Project: **ST GEORGE HOSPITAL  
EMERGENCY DEPARTMENT**

Report: **BCA ASSESSMENT REPORT**

Date: 20<sup>th</sup> March 2012

EAST ELEVATION/SECTION FROM EXISTING LOADING DOCK

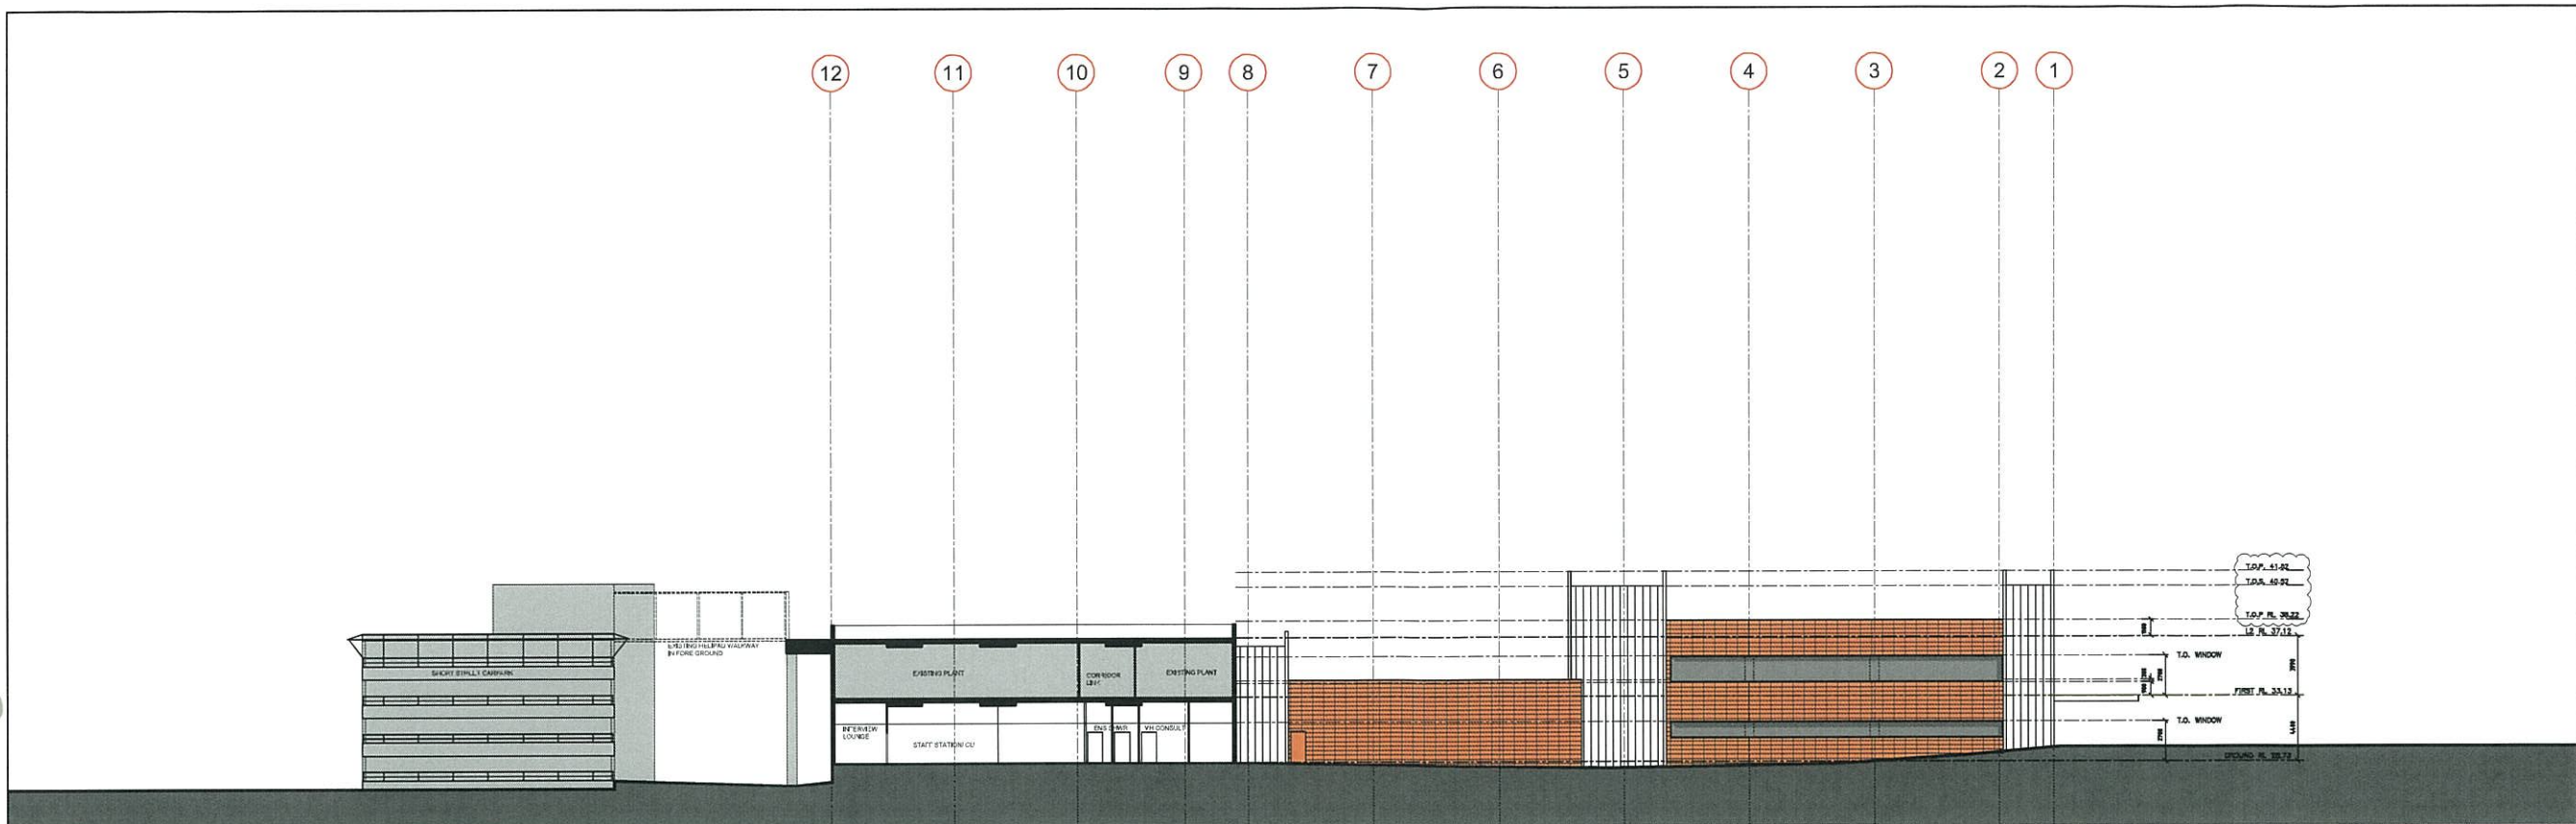
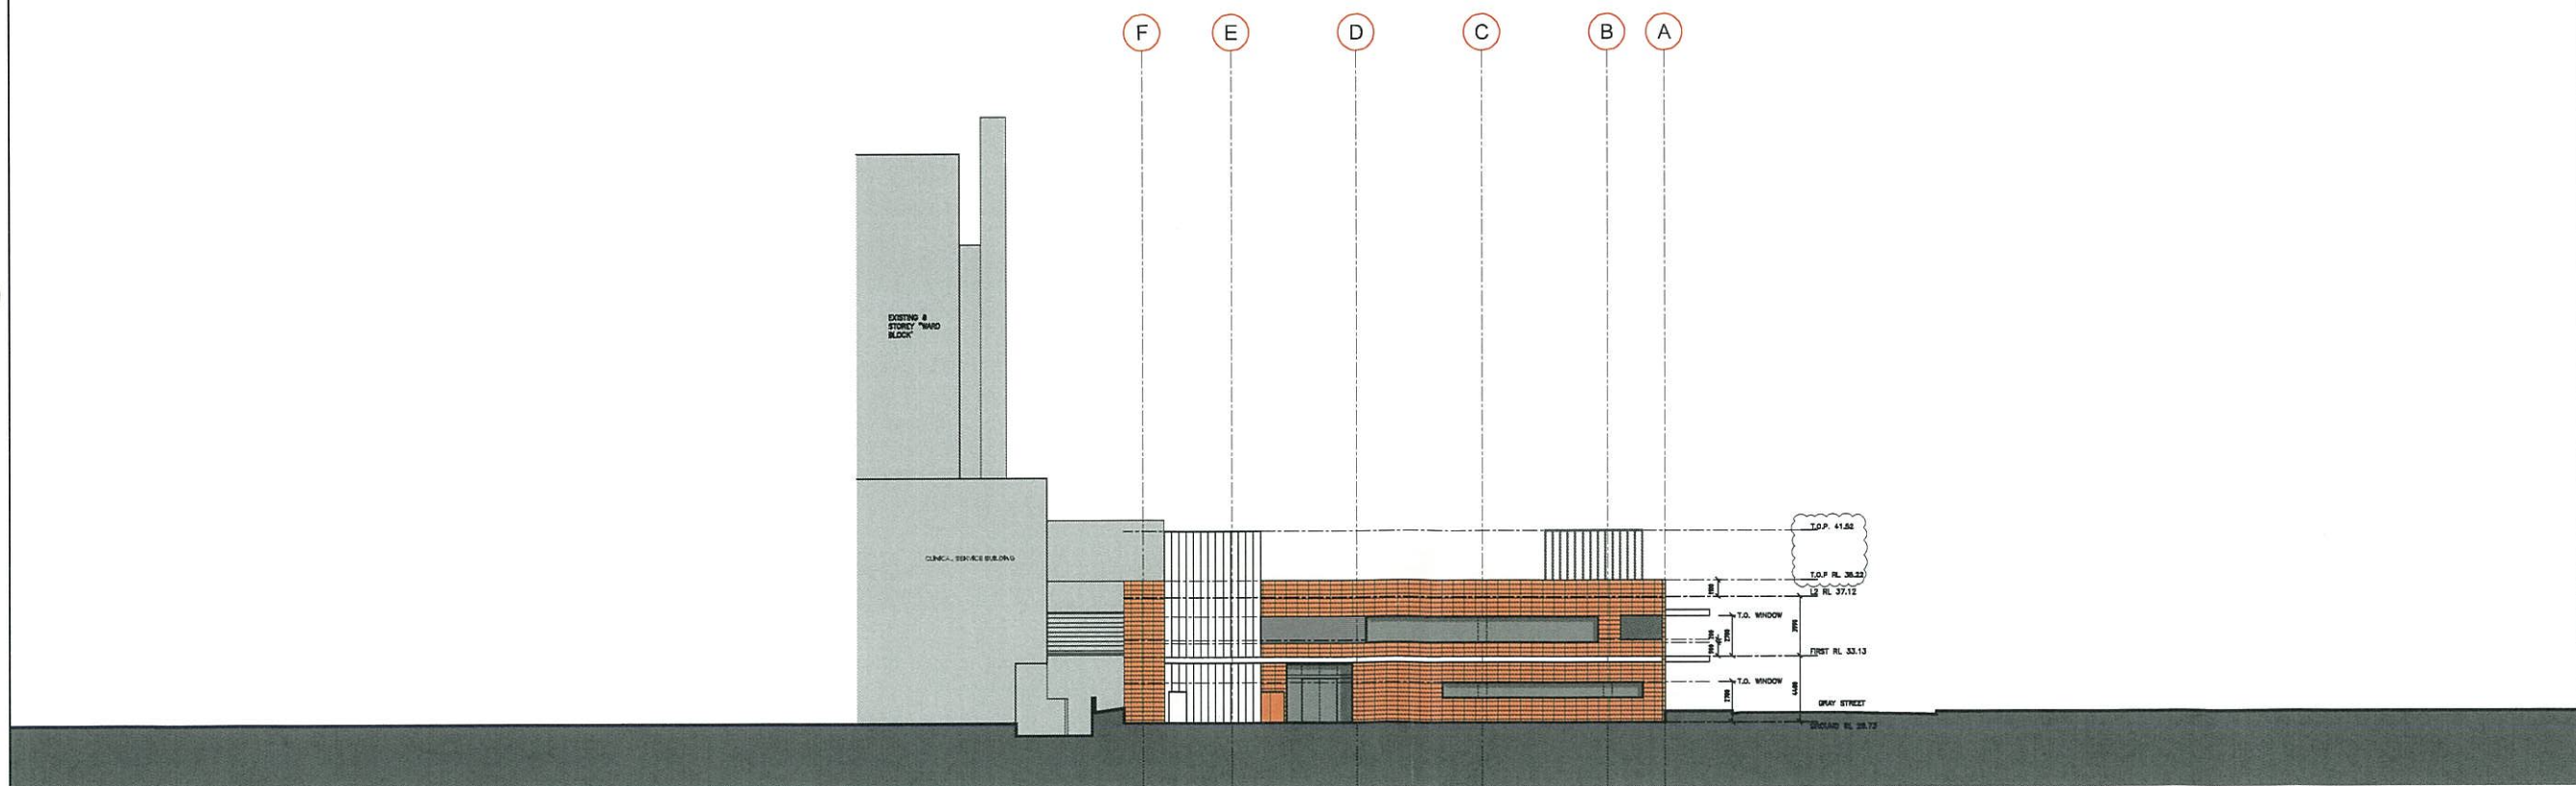
- C. The wall of the external walls imaging room on the ground floor;
- D. The entire external wall to the east of gridline E;
- E. The corridor link to the existing hospital and the fire lock.
